From: Contact Centre (CRM) <contact@ribblevalley.gov.uk>
Sent: 05 December 2022 16:08
To: Planning
Subject: Planning Application Comments - 03/2022/1044 FS-Case-469854863

Planning Application Reference No.: 03/2022/1044

Address of Development: Mitton grange, mitton road, Calderstones park

Drawing file: planx_downloads / 22_1044_s257_Footpath_Diversion_Plan.pdf

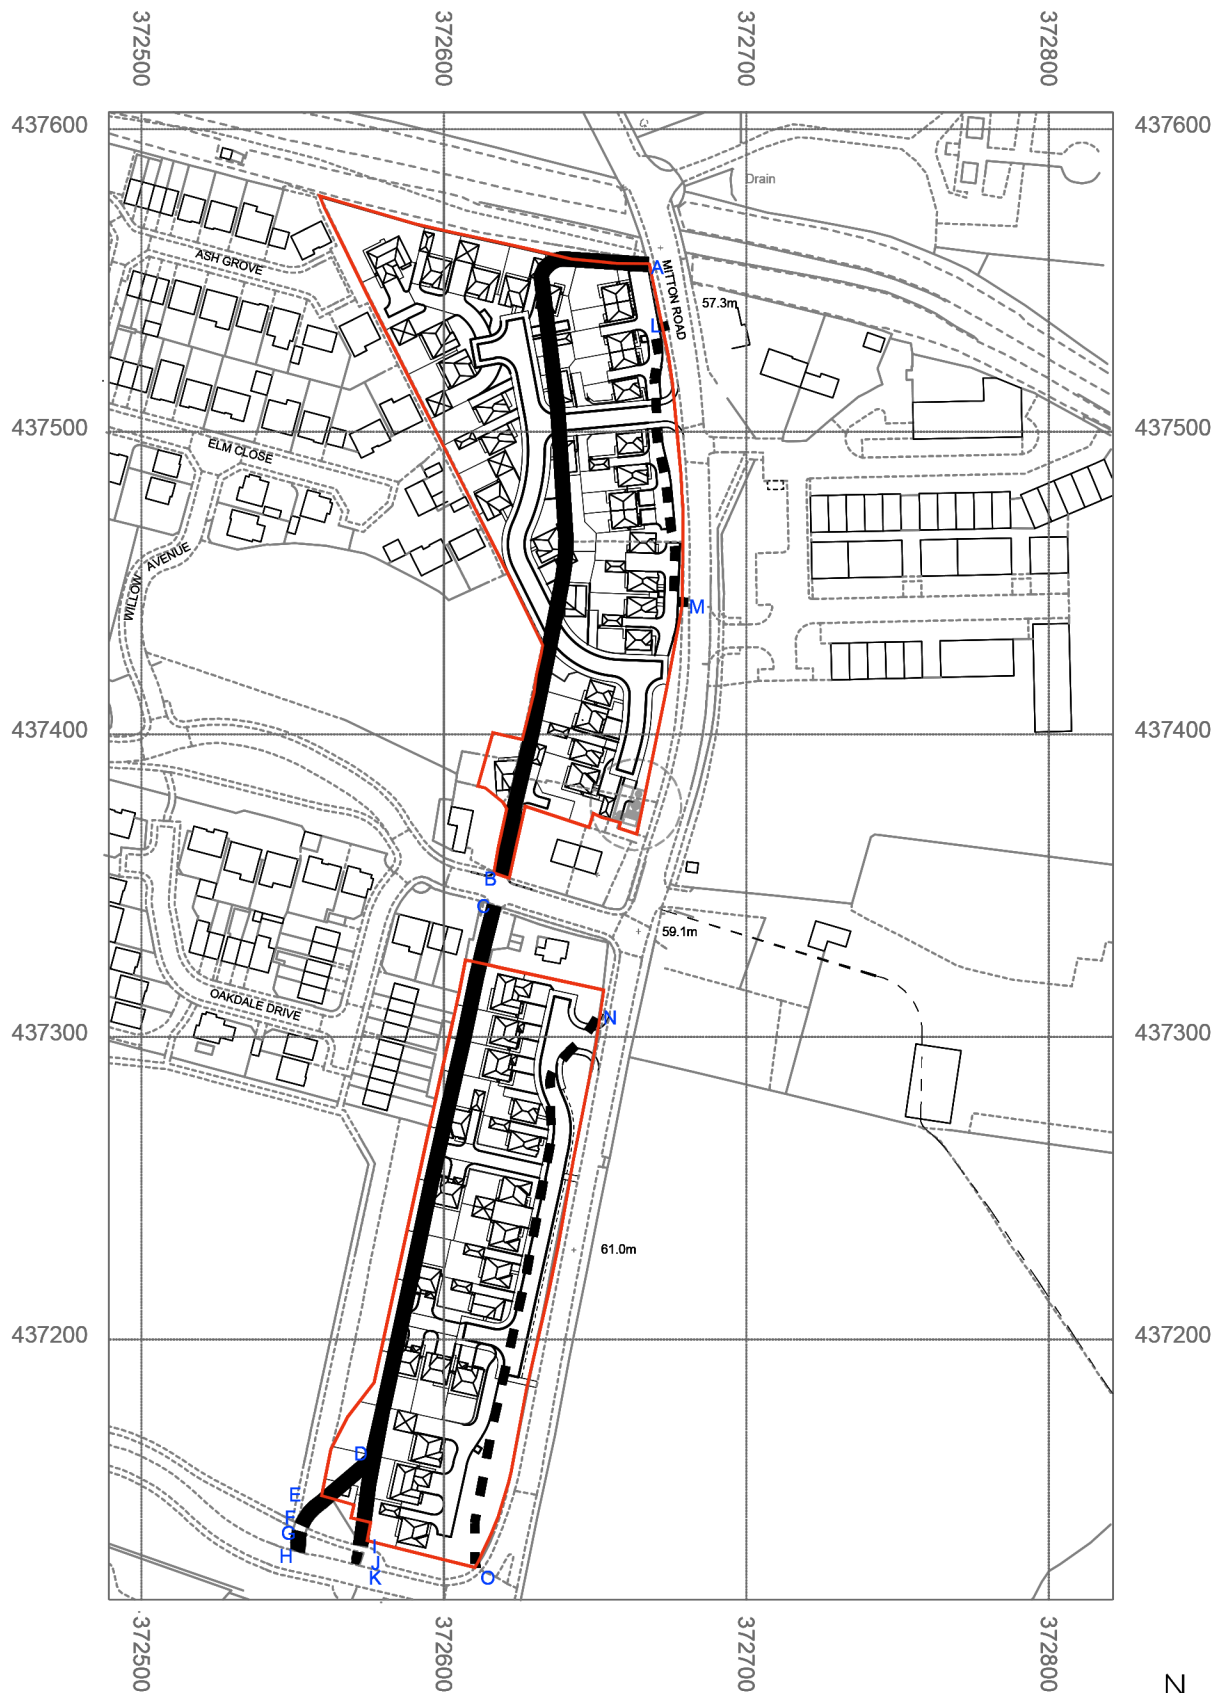
Comments: The path where it is at the back of the houses is much safer being away from the main road. To divert to the front of the houses the pavement is narrow and the speed limit is 50mph on this stretch - I do not feel it is safe or appropriate to move this to the front of the houses.
